# CITY OF ALBUQUERQUE

April 11, 2018

**RE: Sawmill Market  
Drainage Master Plan  
Engineer's Stamp Date: No Stamp  
Hydrology File: J13D017A**

Based upon the information provided in your submittal received 04/02/2018, the Drainage Master Plan **is not** approved for Building Permit and SO-19 Permit. The following comments need to be addressed for approval of the above referenced project:

A1 EXISTING DRAINAGE PLAN

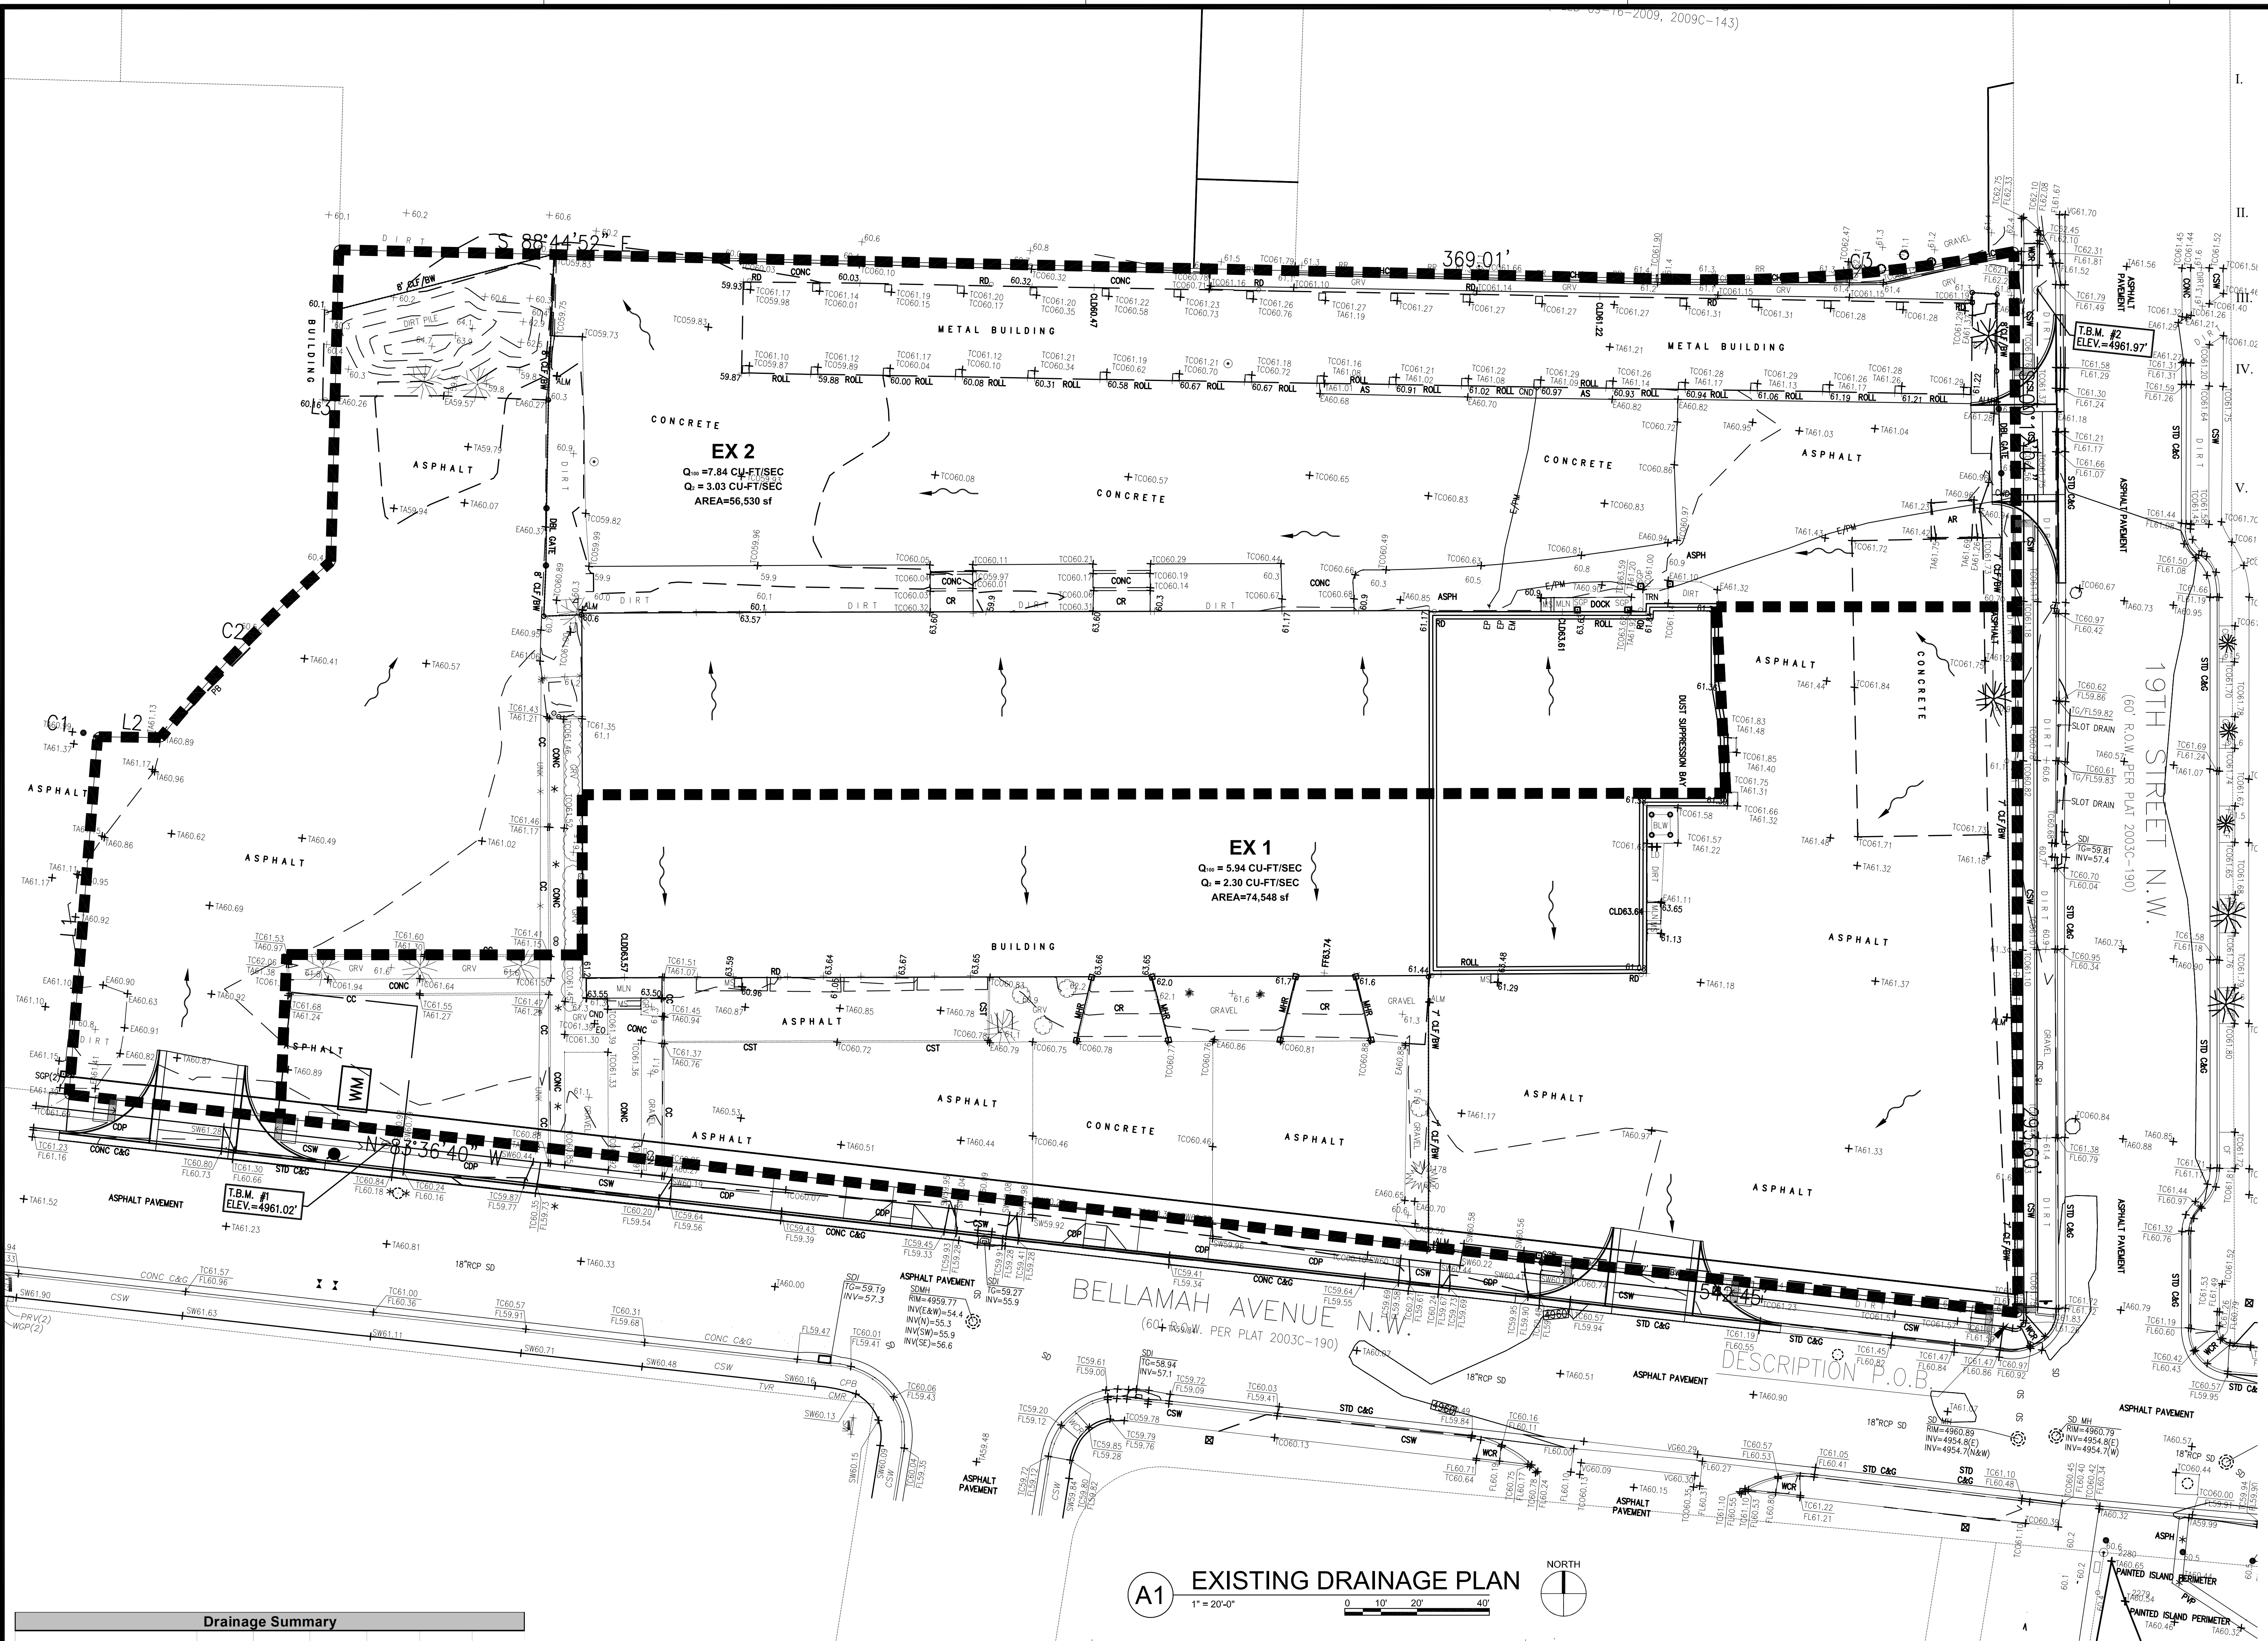
7. Sheet CD1 & CD2. Please correct the drainage calculations to reflect the allowable discharge for the impervious is 0.1 cfs/ac. The allowable discharge is  $0.1 * 0.596 = 0.06$  cfs.
8. Sheet CD2. Please show the pond volume calculations with both the water surface elevation (100 yr – 6 hr) and the discharge rate.
9. Sheet CD2. Please show how each pond is to restrict the discharge for a total of 0.06 cfs.
10. Sheet CD2. Please show the first flush volume in each pond.
11. Sheet CD2. Please reference City of Albuquerque standard detail No. 2236 – Sidewalk Culvert with Steel Plate Top at the sidewalk culvert.
12. Grading Plan. Please show the flowline elevations of the sidewalk culverts.
